Client: El Paso County - Department of Public Works
Project: Jimmy Camp Creek DBPS - Alternative Evaluation Report
Job No.: 181301205

**Figure 2-20: Jimmy Camp Creek at Fountain Creek Daily Streamflow, 1976-2021**

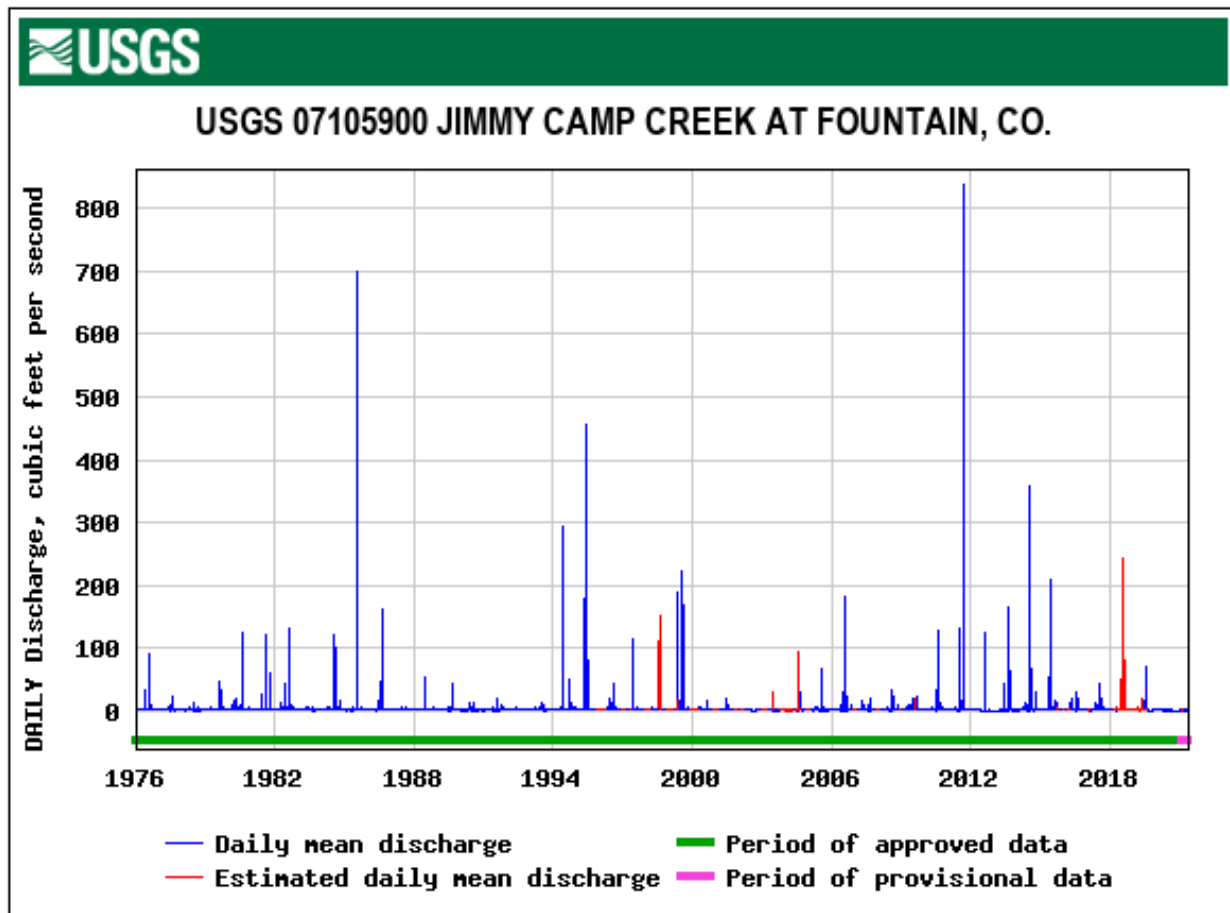
Reviewer				Originator				Reviewer	
Cmnt #	Critical Issue	Reference Dwg, Spec, Page, Sec, Det, etc.	Reviewed By	Review Comments / Questions <i>(Italicized - direct text from Hydraulic Analysis Report)</i>	Response Code	Resolution / Response	Resolution		County Response
							Date	Name	
10		General	EPC Parks	"During the Jimmy Camp Creek Drainage Basin Study, EPC Parks requests assurance that the proposed Jimmy Camp Creek Regional Trail corridor will remain a priority during discussions and planning."	A	Section 6.9 Trails contains a description on how trails can be integrated into the design. This DBPS does not include any detailed trail design and does not address their costs, but the drainage way design can be compatible with future trail design.	8/19/2024	B. Greimann	
11		Section 2.5.3.1	CO Parks & Wildlife	"States that the creek is intermittent all the way until the confluence with Fountain Creek. This statement is incorrect as this section of river always has flowing water, since the United States Geological Survey (USGS) installed the gauge on Ohio Ave in 1981."	A	We agree that the Stream gage does show that the Jimmy Camp can be classified as perennial at the USGS gage site, which is near Ohio Ave. The DBPS only analyzing Jimmy Camp Creek upstream of Link Rd, which is approximately 1.8 miles upstream of Ohio Ave crossing. Based upon field visist and aerial photography, Jimmy Camp Creek is intermittent updatem of Llnk Rd. The Report Text is updated as follows: "Based upon the stream gage record from 1976 to 2021, there is flow in Jimmy Camp Creek at the USGS stream gage more than 99% of the time. However, upstream of Link Rd, Jimmy Camp Creek is frequently dry based upon field visit and aerial photography analysis and can be classified as intermittent."	9/11/2024	B. Greimann	Please confirm Ohio gauge data and update text accordingly

Open Space Composite Analysis

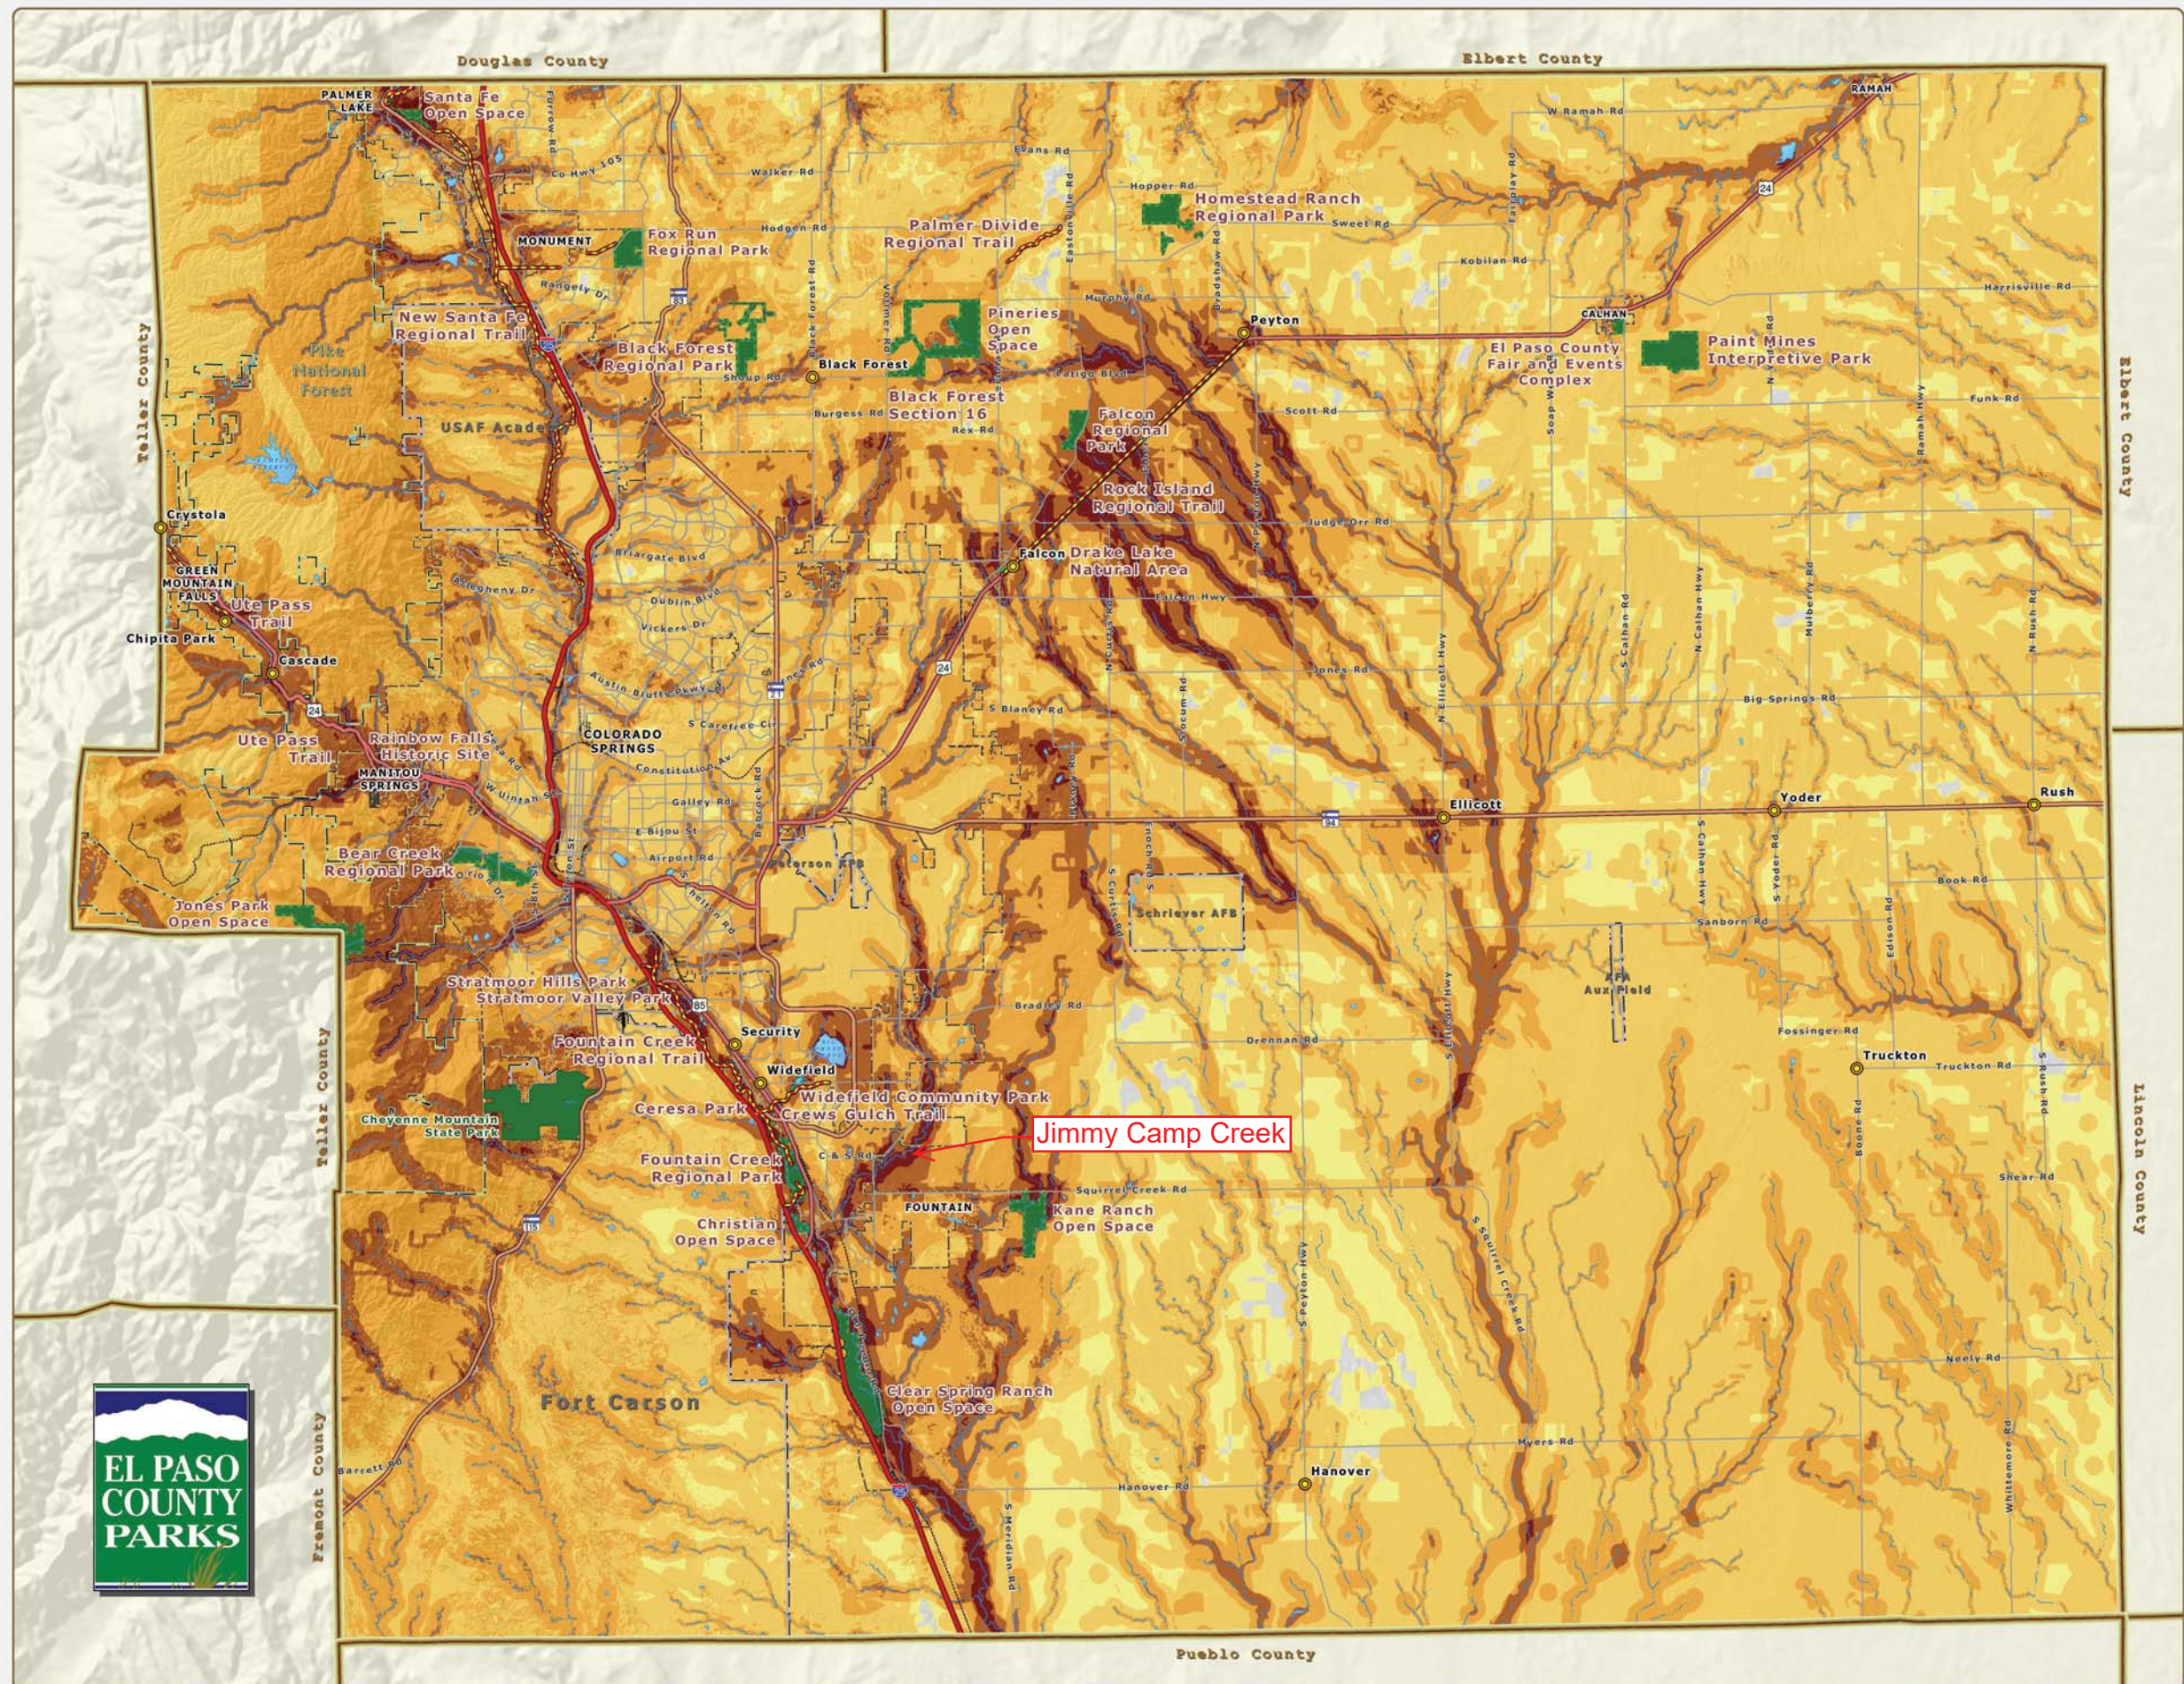
12		Section 2.4	EPC Parks	Suggested text in red: "There are multiple proposed <i>candidate</i> Open Spaces <i>Areas</i> that would be located fully or partially in the Jimmy Camp Creek Drainage Basin. Falcon Garrett Roads Open Space would occupy the broad northeast trending ridge that separates upper Jimmy Camp Creek from the East Fork Sand Creek in the northeast headwaters of the Drainage Basin. Corral Bluffs Open Space would be connected to the southeast of Falcon Garrett Road and would provide an opportunity for a regional trail alignment linking Fountain Creek with Colorado Spring's proposed Jimmy Camp Creek Park. The proposed Fountain and Jimmy Camp Creek Open Space would protect the floodplains of both creeks and the nearby wildlife, including the globally-vulnerable Arkansas Darters that live in the spring-fed marshes adjacent to the main creek channels (EPC, 2022)."	A	Requested changes are made. Reference is changed to 2022.	9/11/2024	B. Greimann	Please reference the 2022 EPC Parks Master Plan instead of the 2013 MP, throughout document
